Document name: 19310-EDGE-XX-XX-CO-C-0002_LLFA RESPONSE[P01]

Re: 19310 – Hawthorne Farm, Clitheroe – LLFA response

With regards to the comments received from the LLFA, quoted below, concerning the drainage proposals and specifically discharge of condition 9 of planning decision 3/2019/1104, EDGE provide this letter and accompanying drawing and calculations in response to the comment.

MANHOLE S10 HYDROBRAKE  
SECTION A

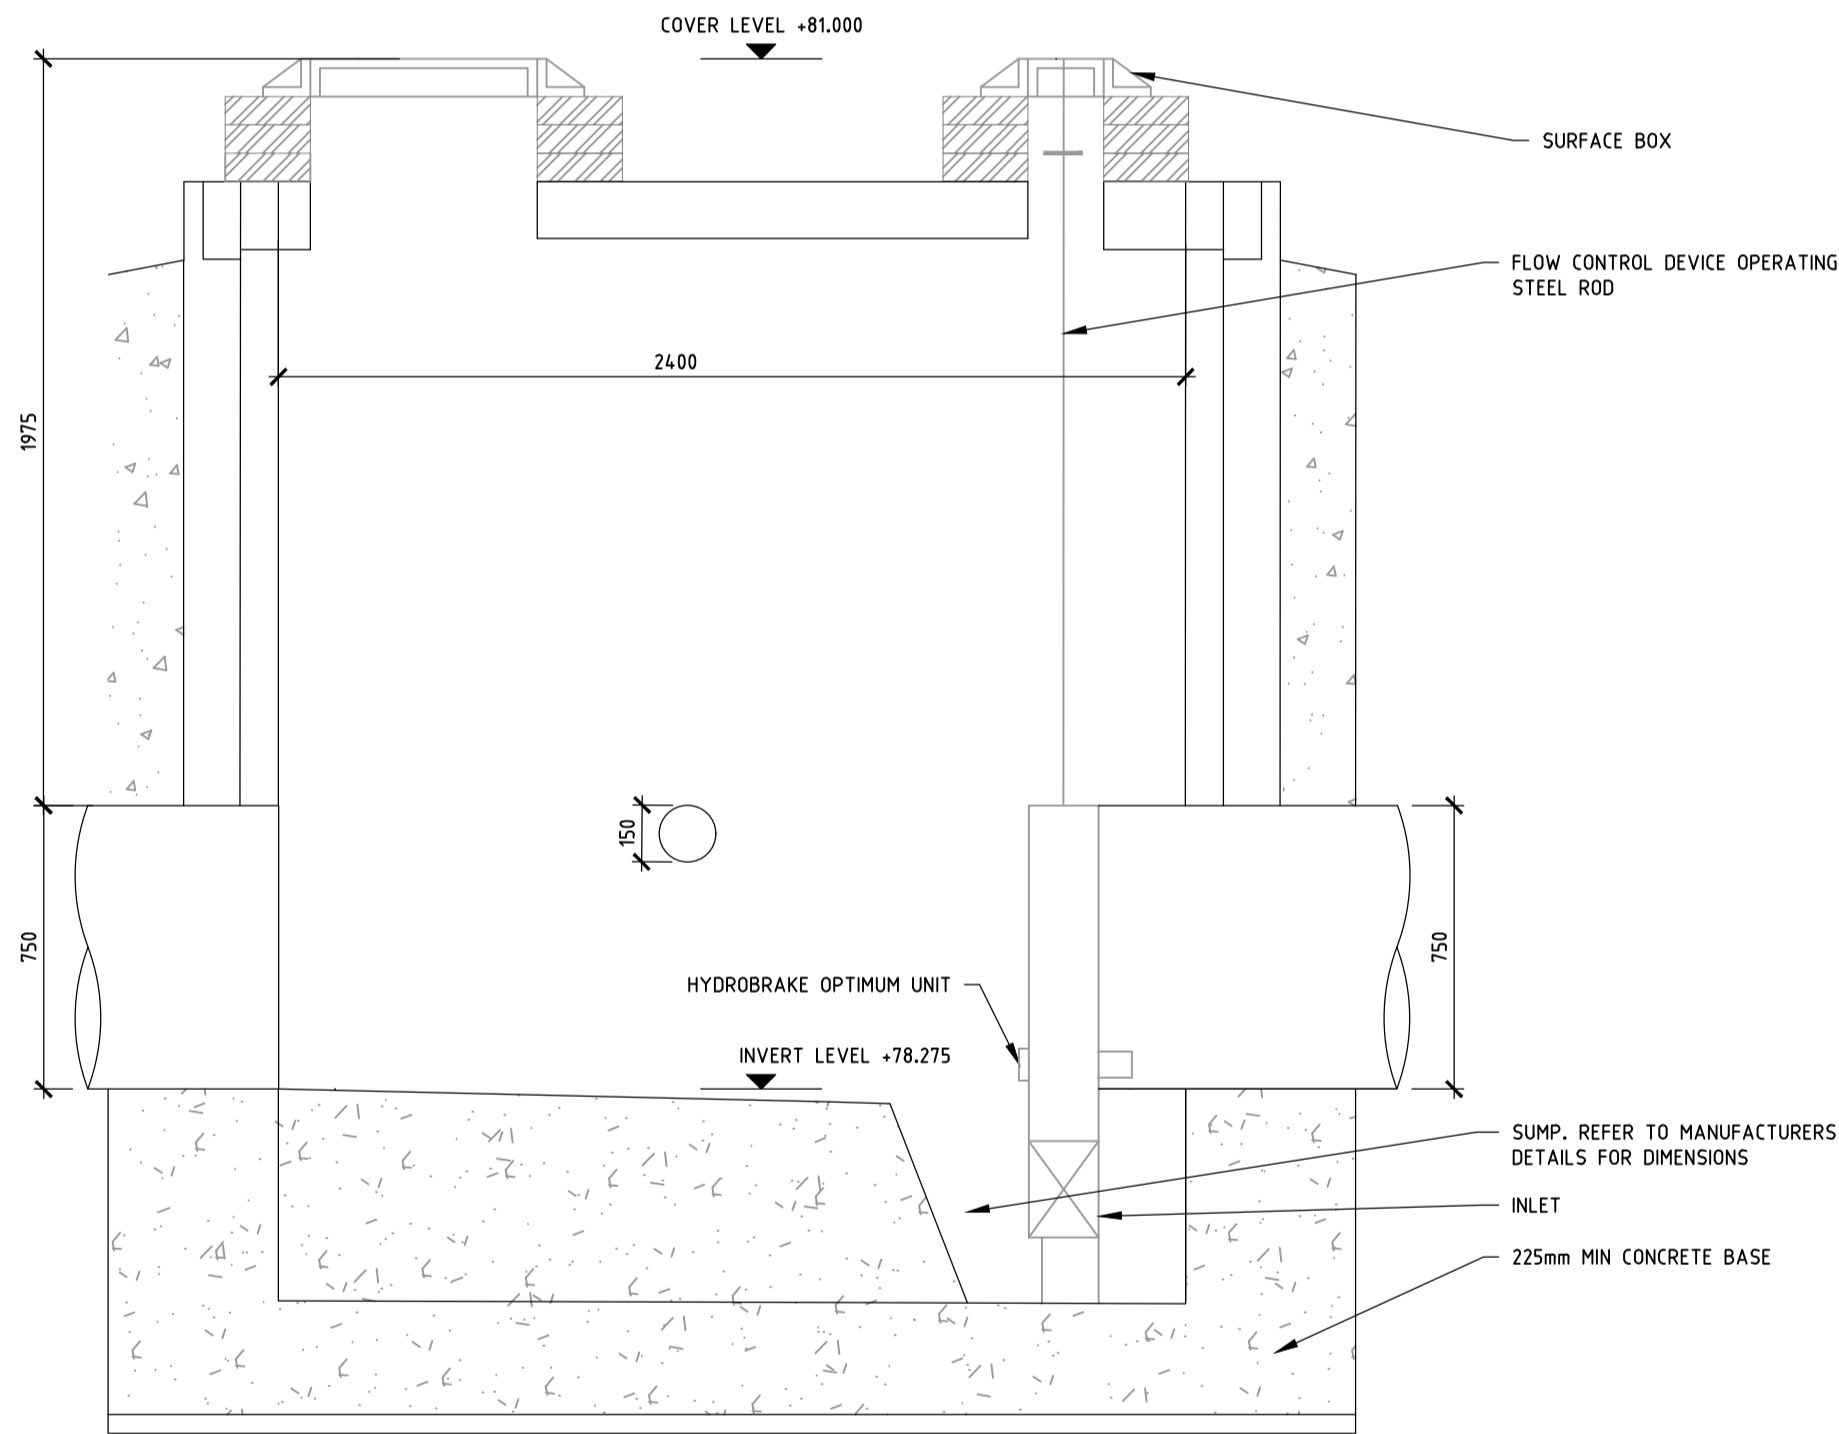
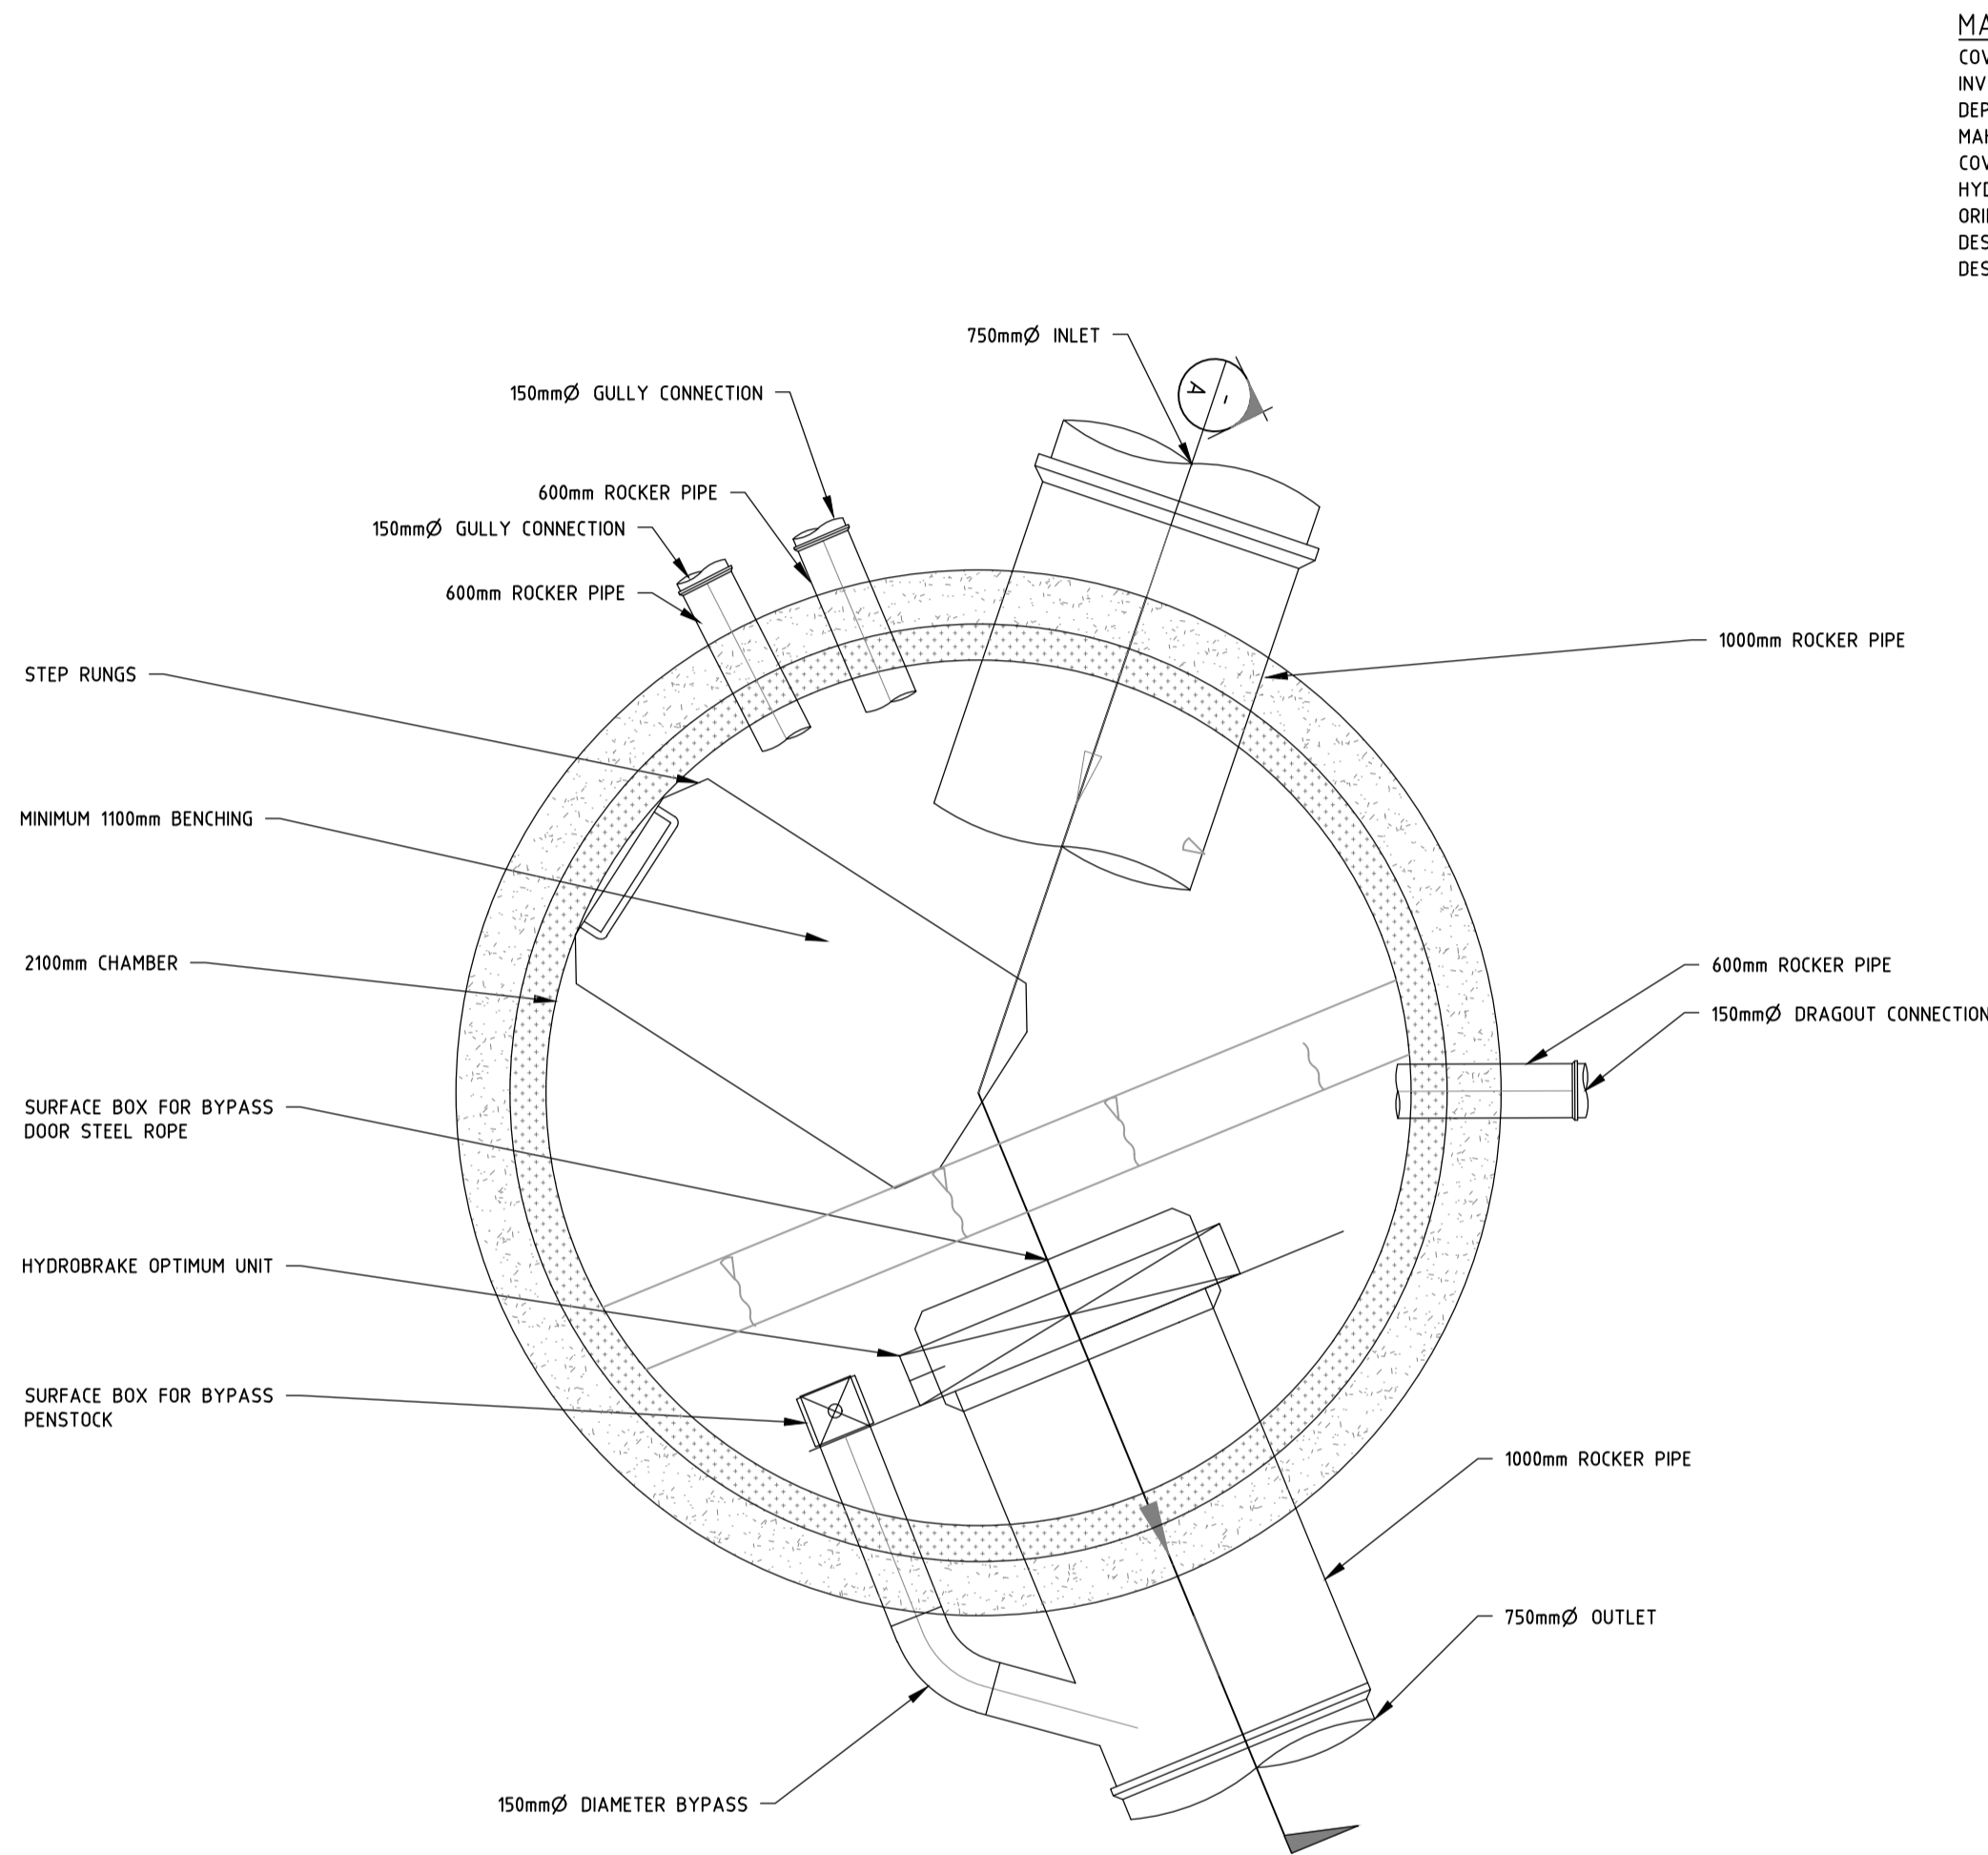
• The applicant has failed to provide evidence of how the proposed filter drain along the southern and eastern boundary has been designed, in order to demonstrate that the proposed drain will not increase flood risk or increase the overall discharge rate from the development given its proposal to connect to diverted culverted watercourse.”

EDGE have deducted this amount from the proposed hydro-brake which is now designed to discharge a maximum of 10.9 l/s. Therefore, the gross runoff rate (from both the hydro-brake and the land drains) does not exceed the approved greenfield runoff rate for the site (11.7 l/s).
